*To Protect and Promote the Health and the Environment of the People of Kittitas County*

RE: Hansen SP-13-00007

Thank you for the opportunity to comment on the Hansen Short Plat, SP-13-00007.

**HANSEN SHORT PLAT
 PART OF SECTION 8, T. 17 N., R. 18 E., W.M.
 KITITAS COUNTY, WASHINGTON**

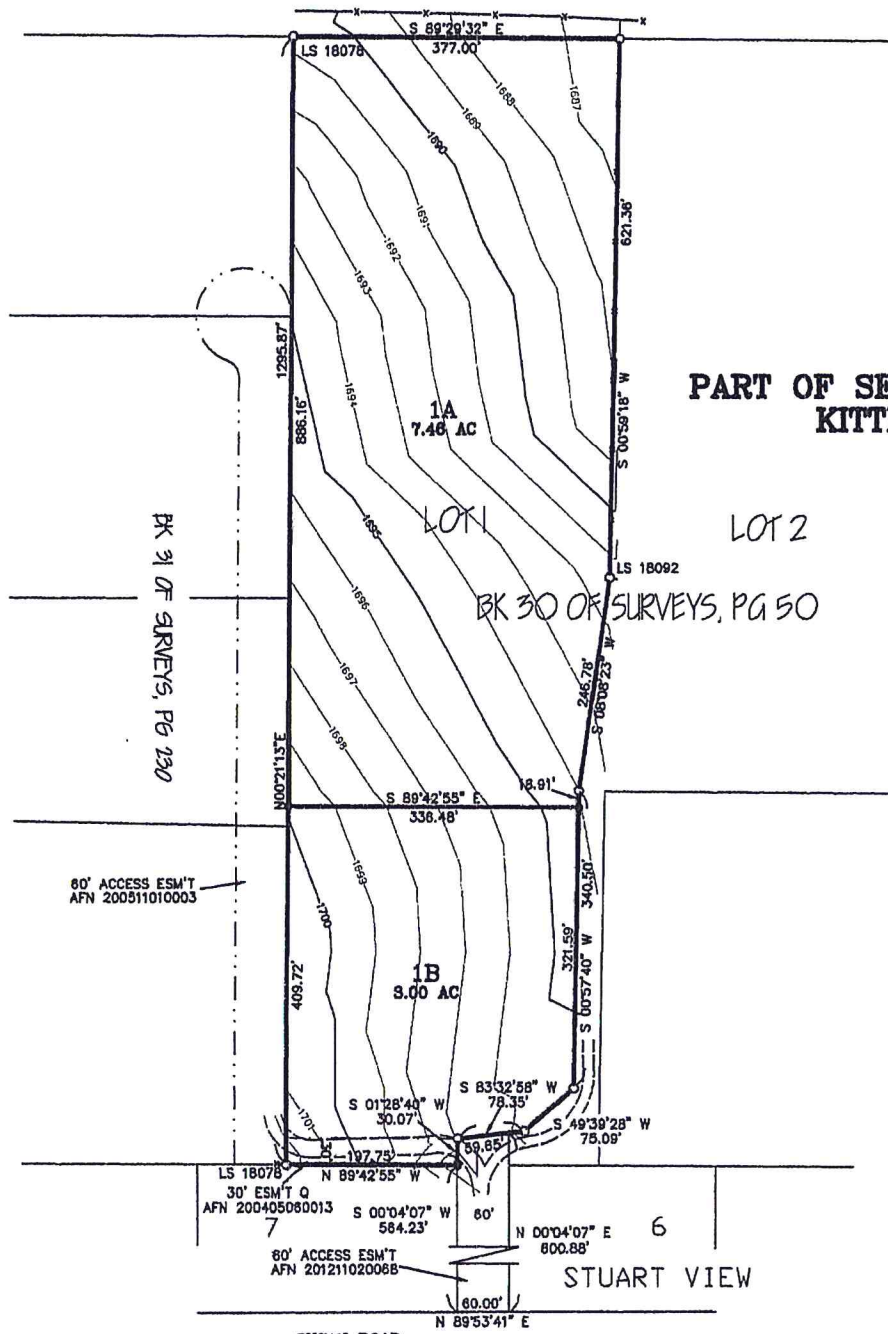
The proposed Short plat will require a minimum of one soil log or site evaluation on each proposed lot. It appears that there are no wells located on either proposed lot, you will either need to drill a well on each lot or drill one well on a lot and provide a recorded shared well users agreement along with the other requirements. The above mentioned requirements need to be satisfied and the appropriate

documentation needs to be submitted to KCPHD for review and approval in order for the plat application to be recommended for final approval.
